# Rezoning Transportation Analysis

Petition Number: 2021-152

Date	Description
11-19-21	First Review (TM)
12-20-21	Second Review (PDM)

Apprvd:	
Date:	5/27/2021
Chkd:	SM
Drwn:	SK
Scale:	1"=20'
Project No.:	2021-009
Sheet:	RZ-1

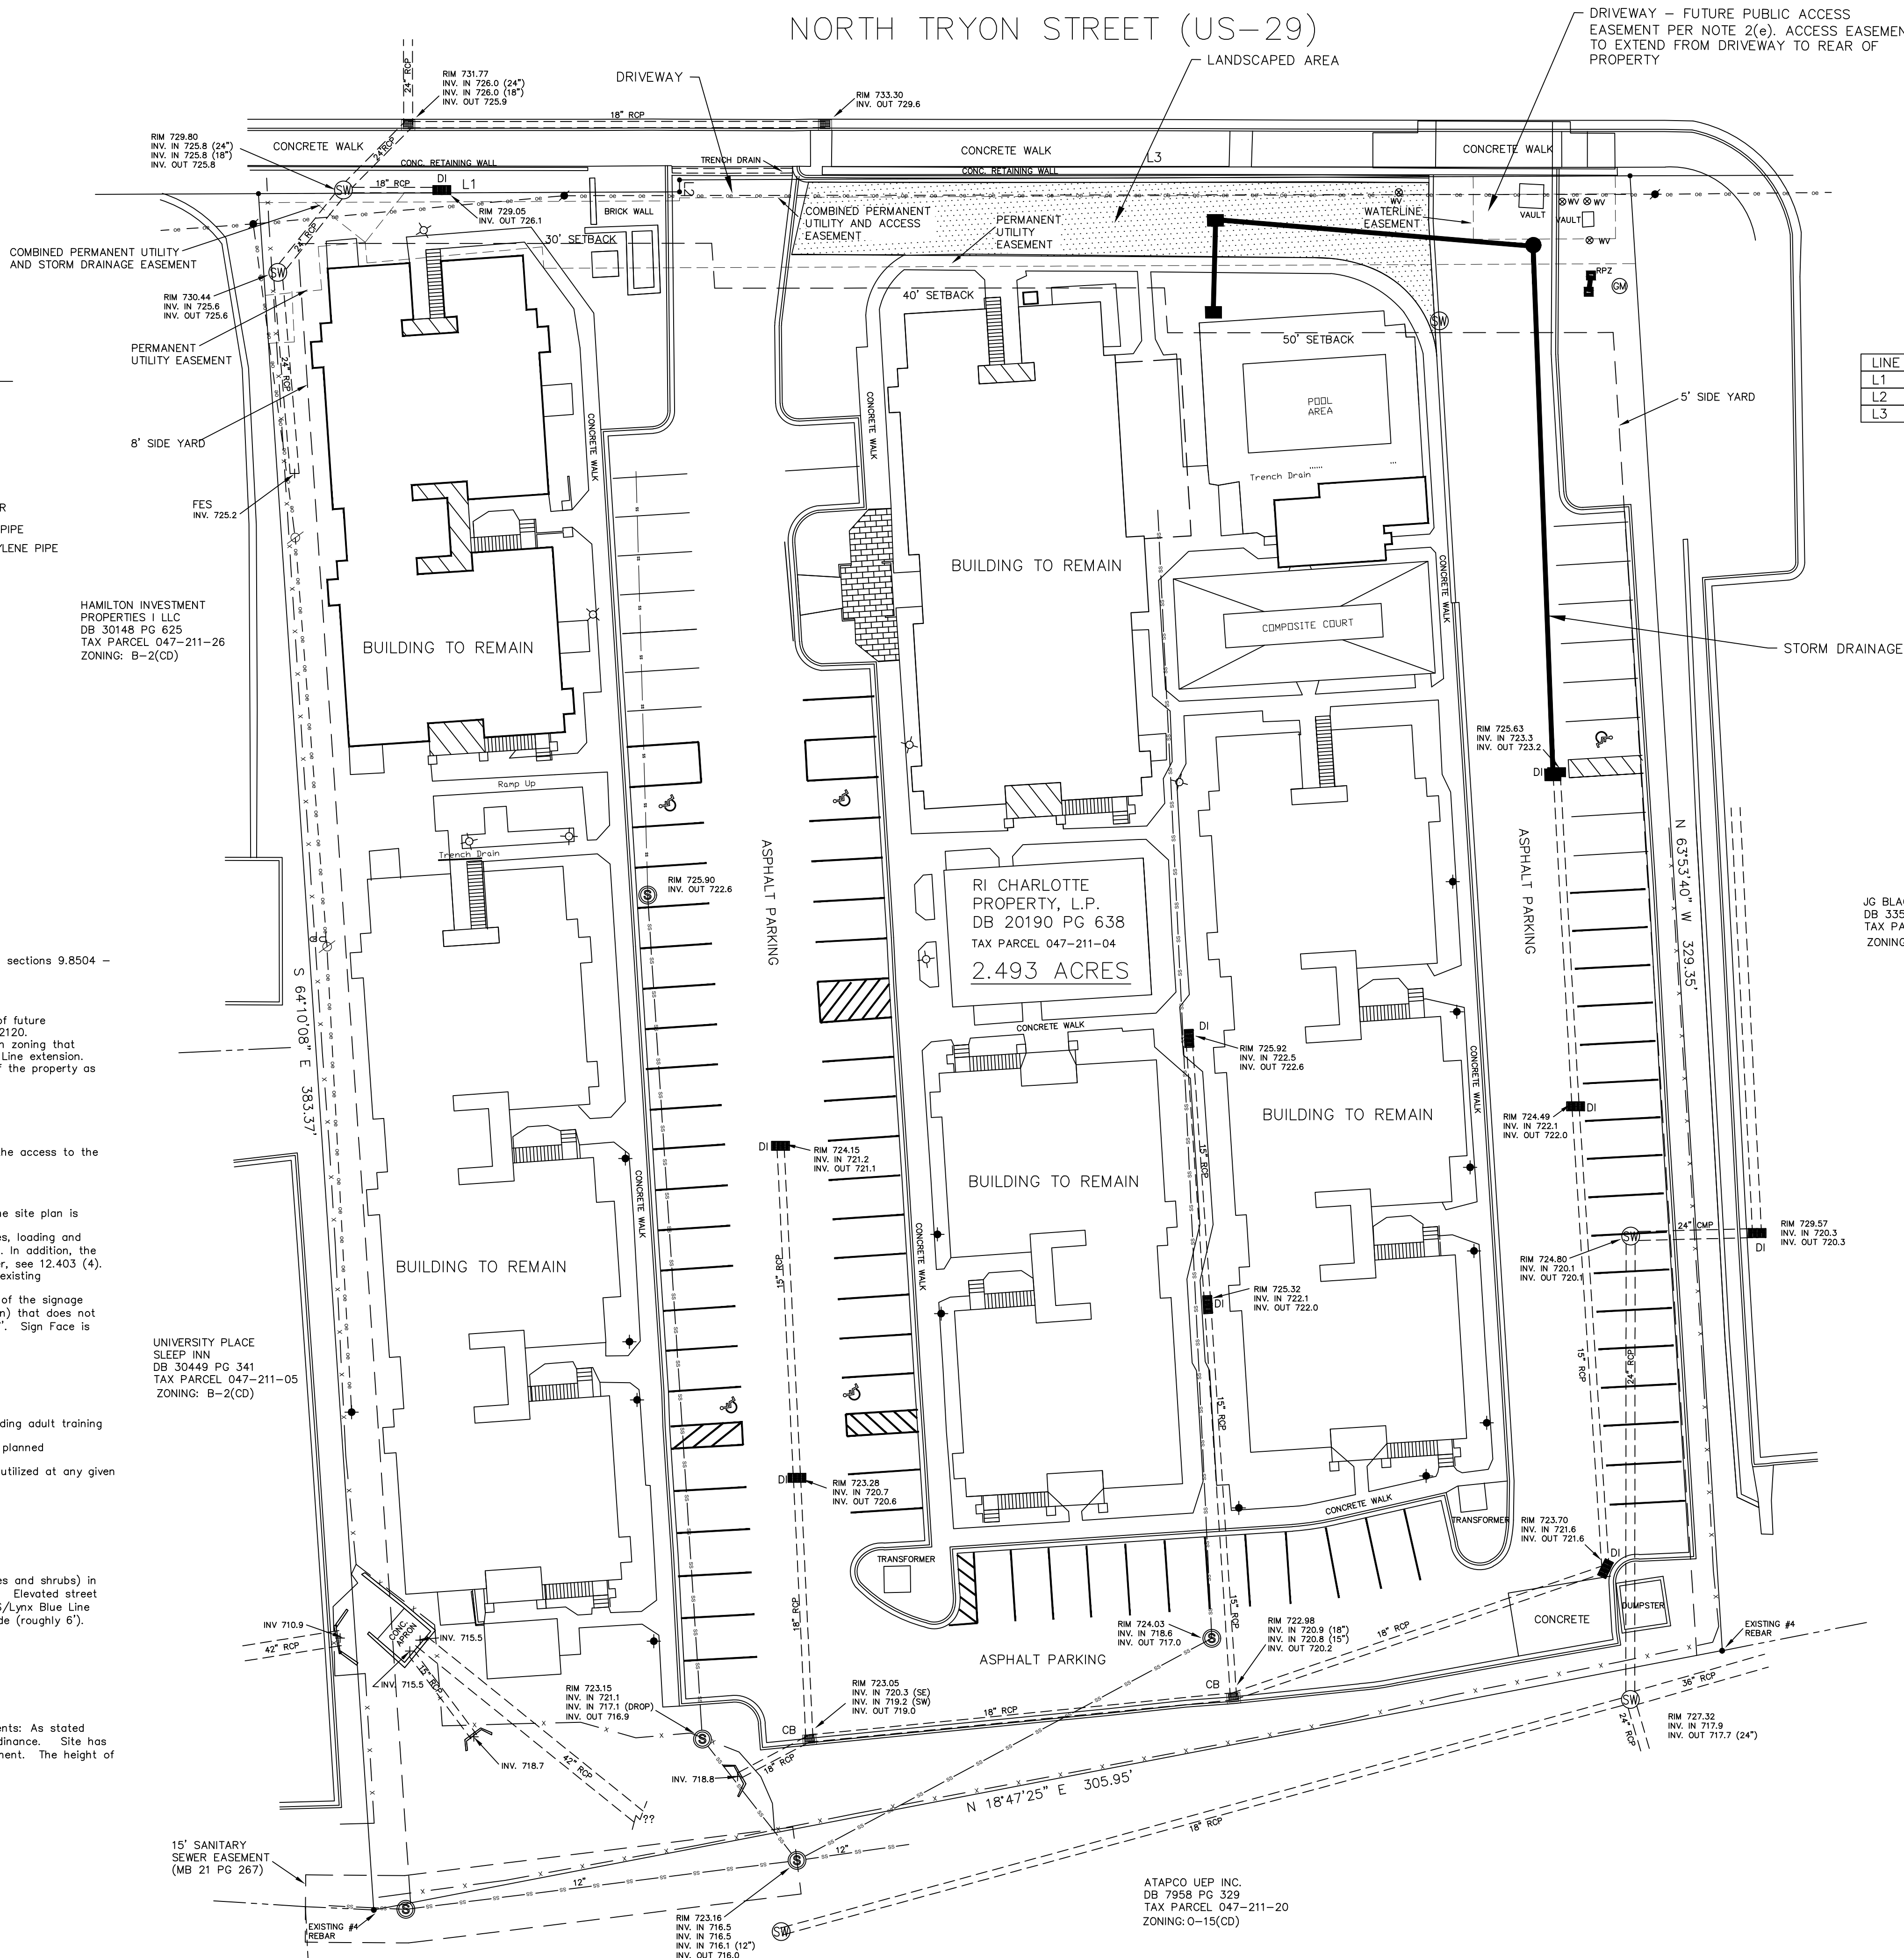
- ~~Revise site plan by dimensioning the right of way from the existing centerline of Tryon Street.~~
- ~~Add conditional note "All public roadway improvements will be subject to the standards and criteria of CDOT and NCDOT, as applicable, to the roadway improvements within their respective road system authority. It is understood that such improvements may be undertaken by the Petitioner on its own or in conjunction with other development or roadway projects taking place within the broad north eastern Mecklenburg area, by way of a private/public partnership effort or other public sector project support."~~
